January 10, 2020 UPDATE (6<sup>th</sup> Supplemental Submittal)

**RE: KMART REDEVELOPMENT – DRB SUBMITTAL FOR SITE PLAN**

**DRB PROJECT NUMBER: PR –2019–002677**  
**APPLICATION NUMBER: SI-2019-00252**

**16 CURBED RAMP DETAIL**  
N.T.S.

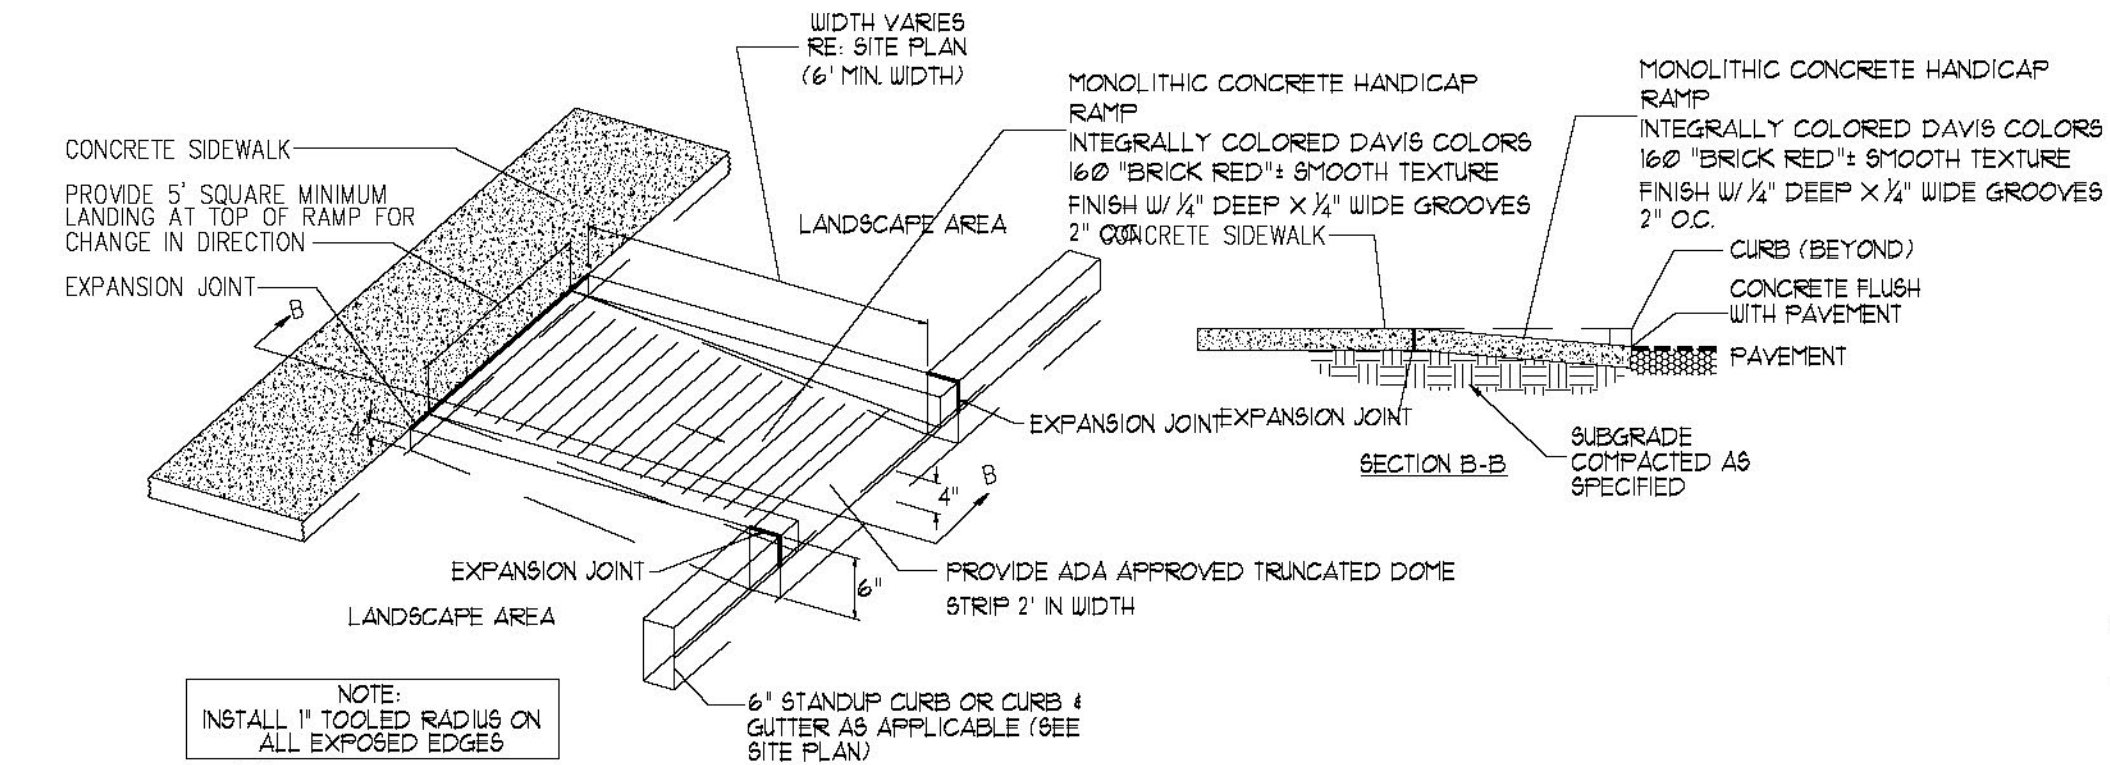
6. On Sheet A1.1, where is cross-section A-A for the curb ramp?
  - a. **See sheet A1.1 - Site Details, note 16 (See bottom right corner of note 16 "Section B-B")**

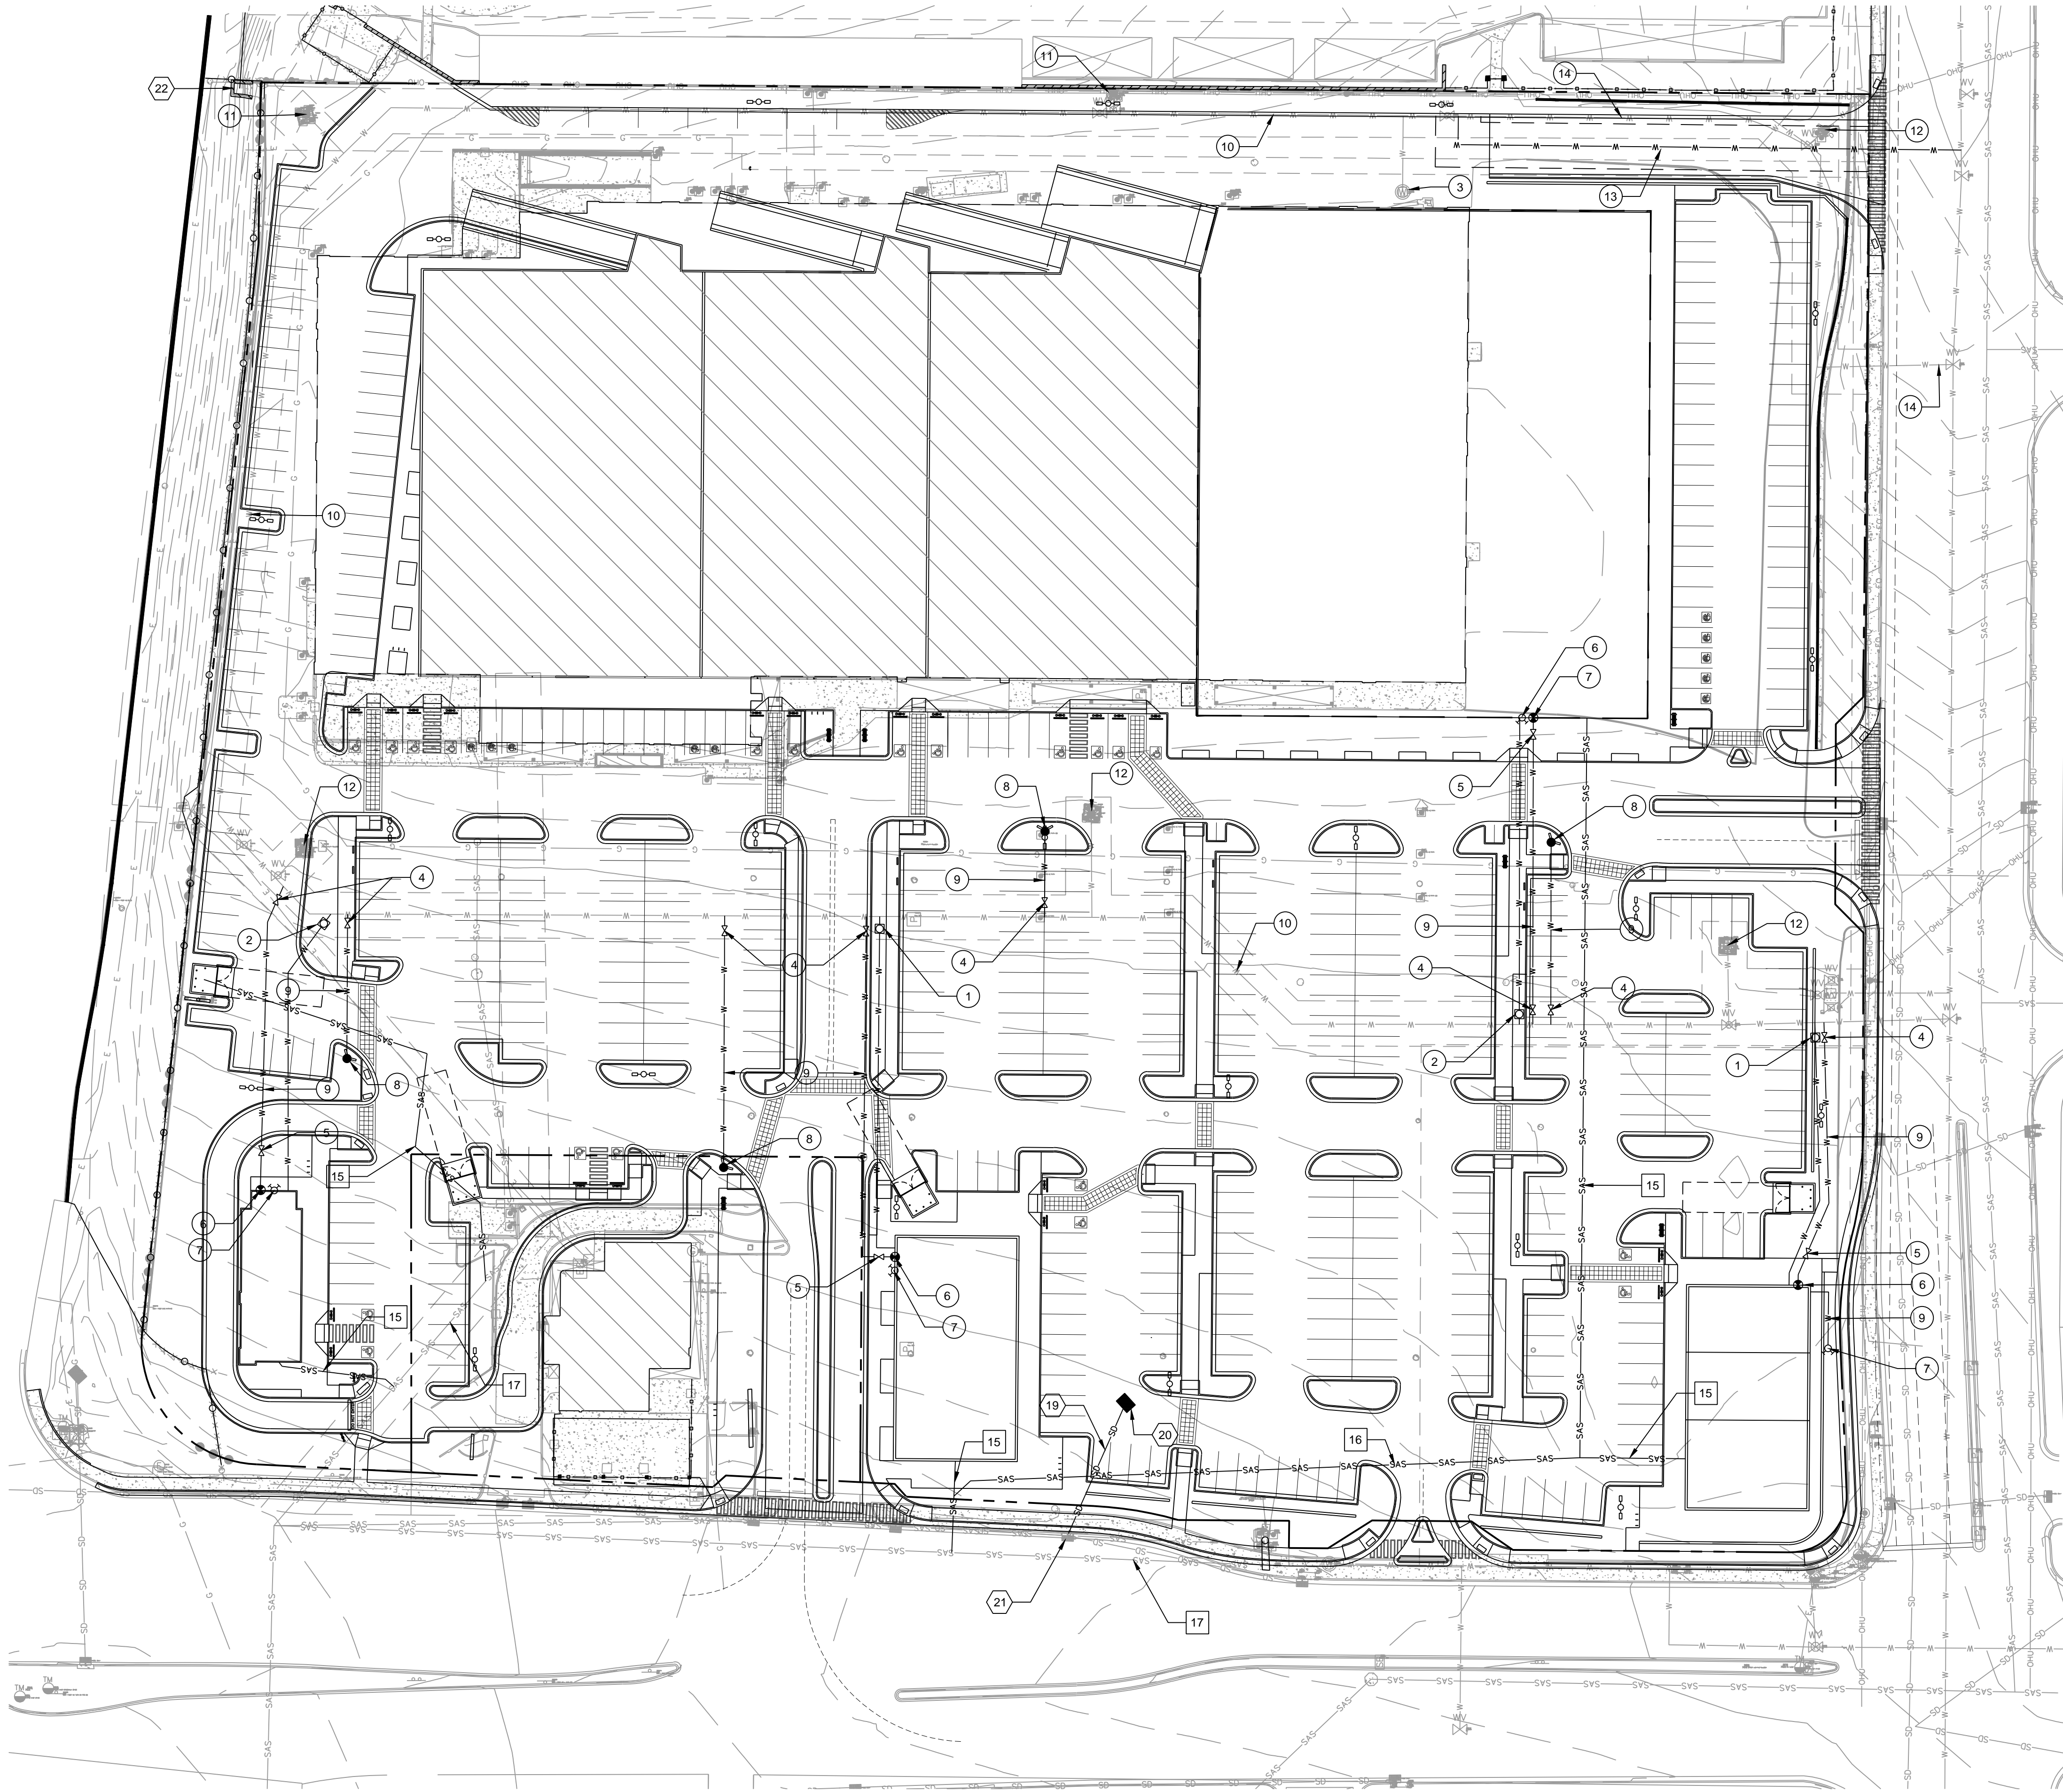
- c. Proposed onsite fire hydrants shall be deemed private. It is understood that there are several onsite public fire hydrants but the proposed fire hydrants legs are quite long and resemble a private fire line.

- i. Response was all existing and proposed hydrants are now shown as private. Simply renaming the existing public hydrants to private does not convert them as such. Please coordinate with Maps & Records and label accordingly. Some onsite existing fire hydrants may be in easements, making them public. Please confirm.

1. How will the existing public fire hydrant(s) be converted to private as per Note 11? If there is an existing easement, then this will need to be vacated. Otherwise, it will remain as public.

- d. **All existing hydrants onsite are public. All new hydrants, as noted on the plan, will be private. Most of the existing hydrants onsite will be removed with the exception being two hydrants along the eastern property boundary. These two hydrants will remain public hydrants within the existing easement as indicated on the revised plan.**
